**SSD 9606 – UNSW D14 ACADEMIC BUILDING – ENVIRONMENTAL IMPACT STATEMENT (EIS)**

#### UNSW BUILDING D14 ACADEMIC BUILDING

Figure 3-1 Aerial showing Noise Monitoring Locations

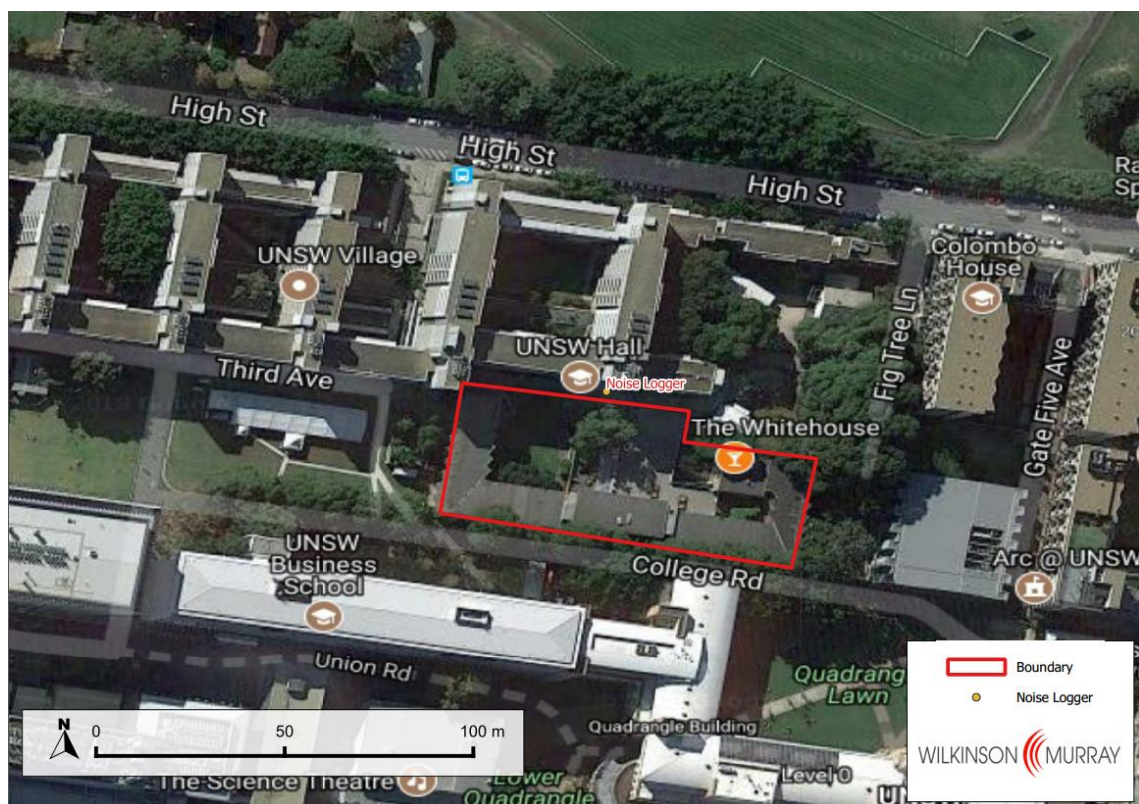
The NPI specifies that at least a 'week's worth' of monitoring data is required to establish background noise levels and that noise levels measured during rainfall should be excluded when deriving those background levels. However, the EPA notes that Figure 3-1 to EIS Appendix K indicates that background noise monitoring was undertaken on the northern side of the development site rather than at the most affected residence to the southeast of the development site

- (a) provide a comprehensive quantitative assessment of operational noise impacts of mechanical plant and equipment (especially ventilation/air conditioning plant and equipment) on surrounding noise sensitive receivers, especially surrounding residences;
- (b) ensure mechanical plant and equipment installed on the development site does not generate, (either individually or cumulatively) –
  - (i) noise emissions that exceed the Project Noise Trigger Level (day, evening and night assessment periods) measured at the boundary of the most affected residence, and
  - (ii) noise emissions that exhibit tonal or other annoying characteristics.
